NSW RURAL FIRE SERVICE

Your reference: SSD-10321
Our reference: DA-2019-01672-EIS & DA
Exhibition-1

State Significant Development – Multi Dwelling Housing
Draft Conditions of Consent
87-89 John Whiteway Drive Gosford NSW 2250, 100//DP1075037

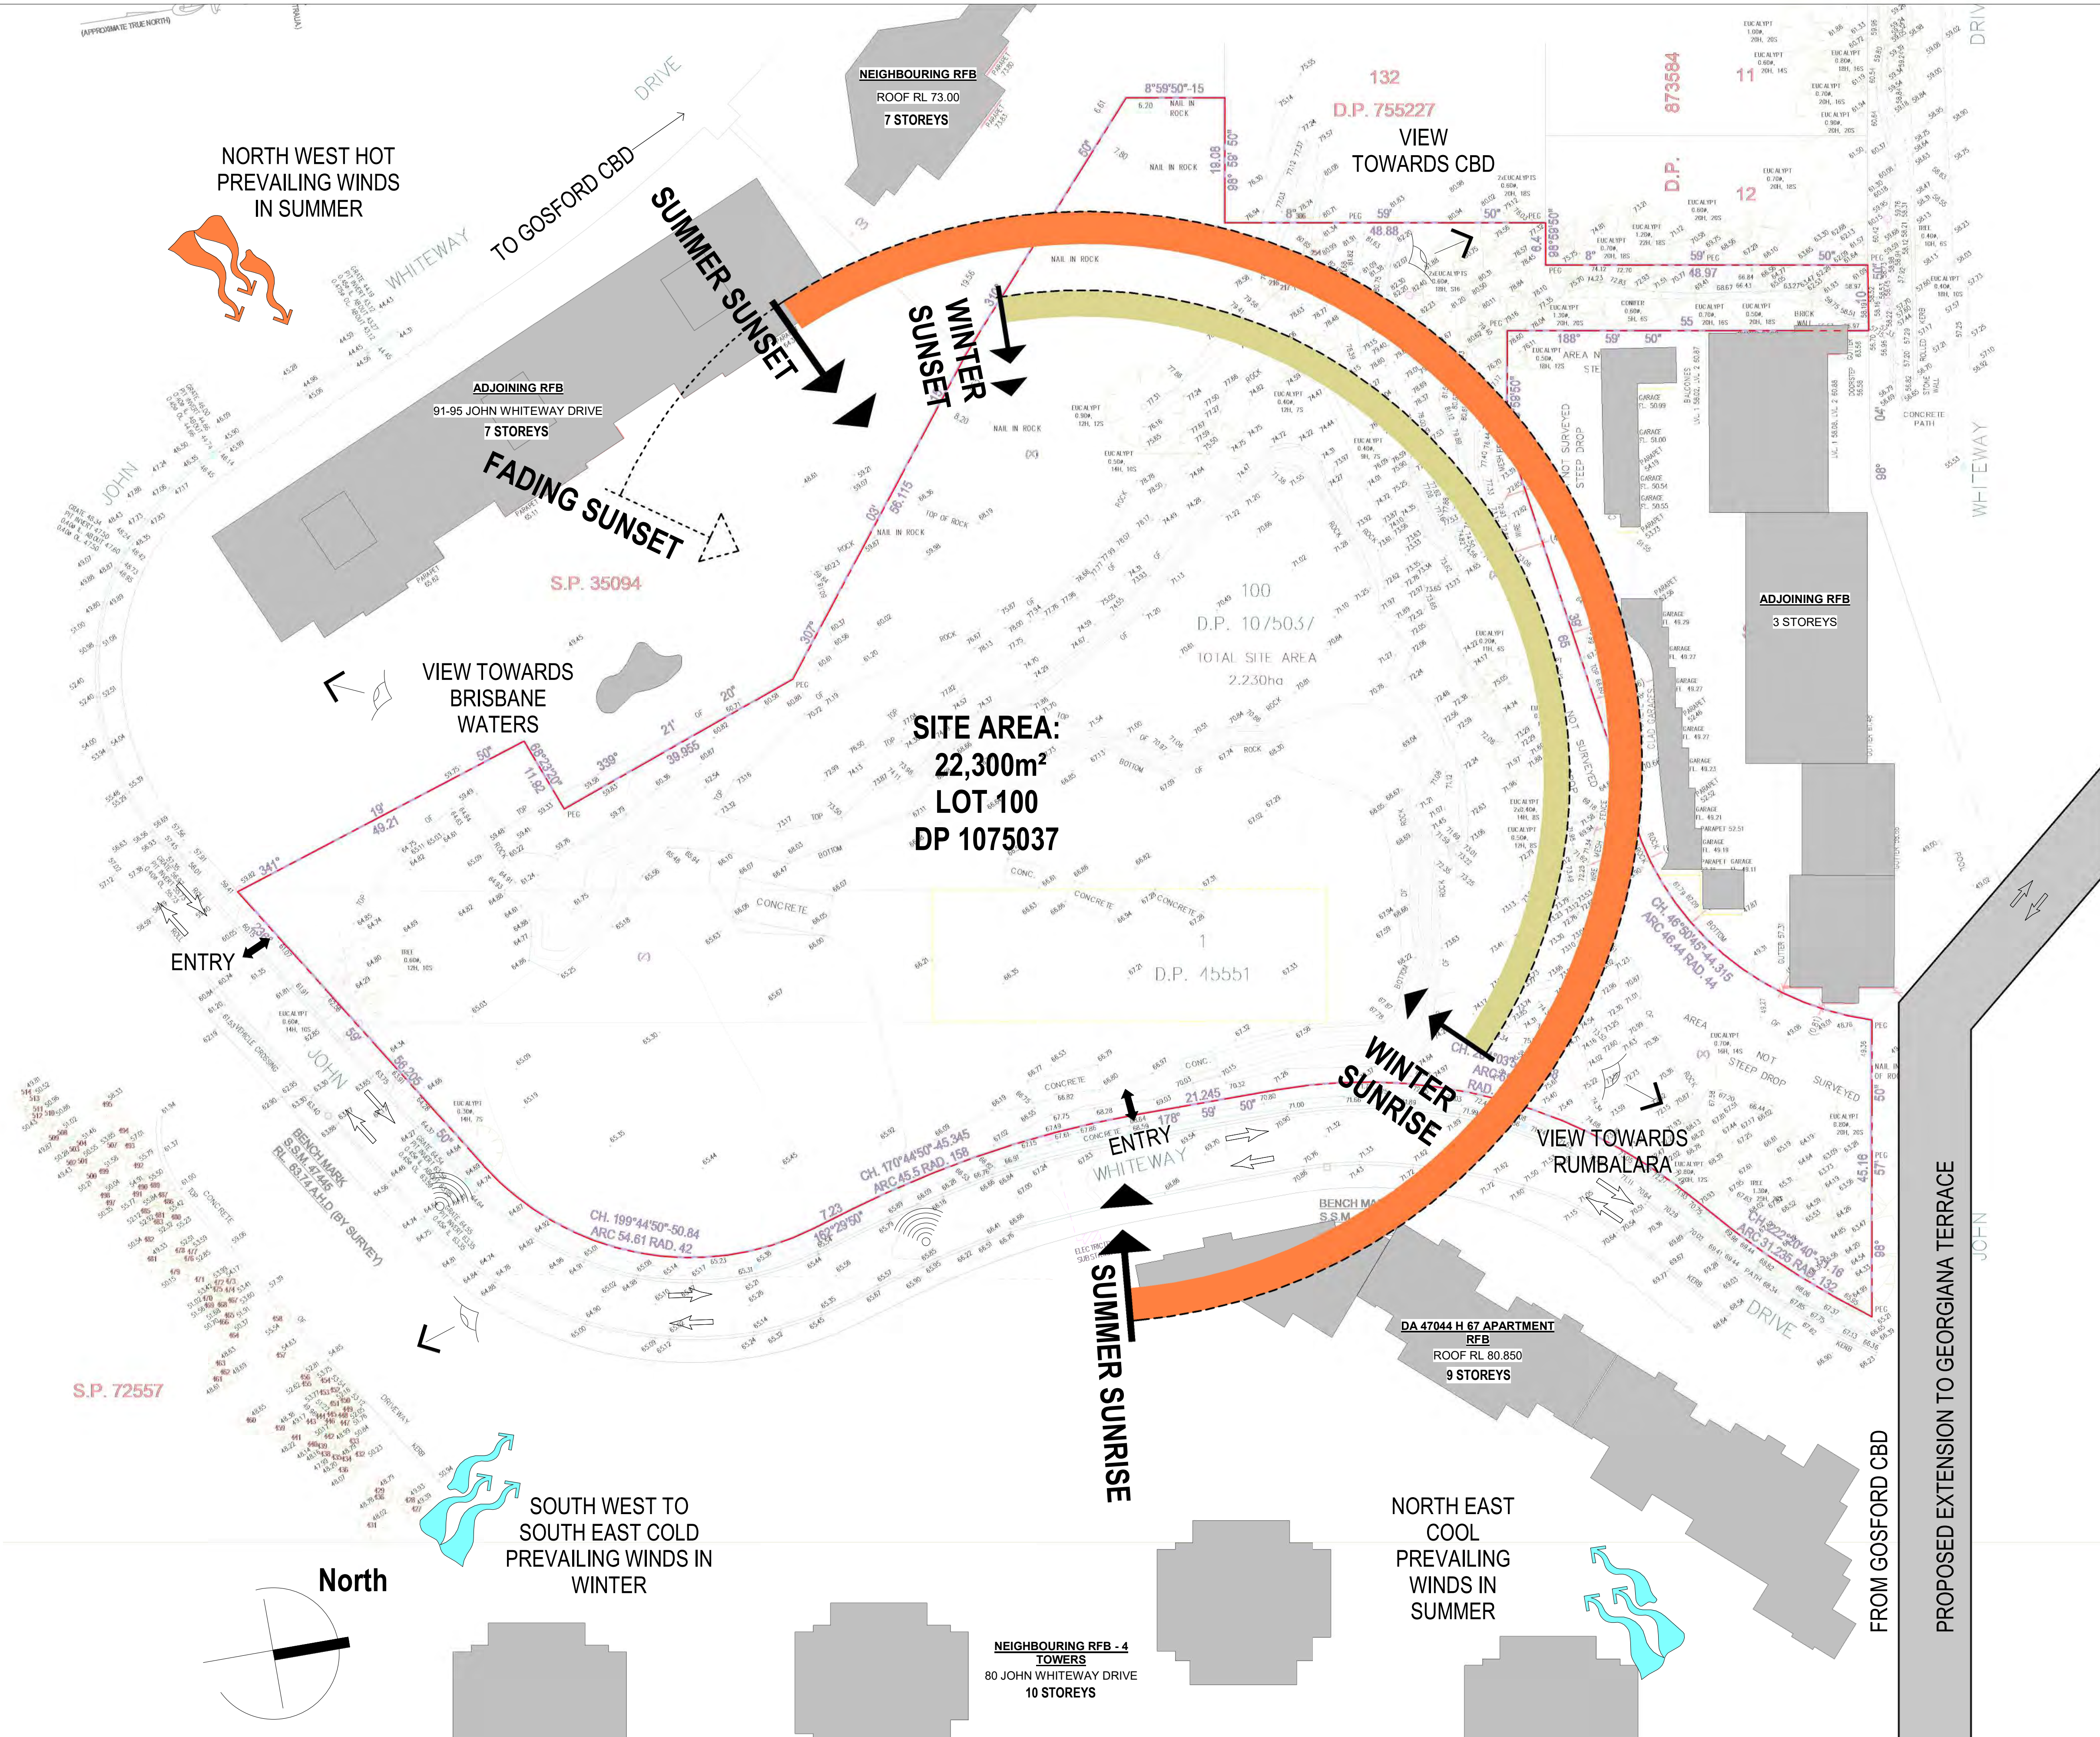
The general terms of approval relate to the Site Plan provided by ADG Architects, project number 19002, drawing number DA001.5, issue 4, dated 20/02/2020.

2. From the start of building works, and in perpetuity to ensure ongoing protection from the impact of bush fires, the entire property must be managed as an inner protection area (IPA) as per the *Vegetation Management Plan* (prepared by Conacher Consulting Pty Ltd, Version 1, February 2020, ref: 9096) in accordance with the requirements of Appendix 4 of *Planning for Bush Fire Protection 2019*. When establishing and maintaining an IPA the following requirements apply:

3. In accordance with section 88B of the *Conveyancing Act 1919*, a restriction to the land use shall be placed on Lot 0/SP72557- 80 John Whiteway Drive Gosford requiring the provision of a 5 metre wide Asset Protection Zone (APZ) along the northwestern boundary beyond the property access ramp, which must be maintained as an Outer Protection Area (OPA) as outlined within Appendix 4 of *Planning for Bush Fire Protection 2019*. The OPA must comprise:
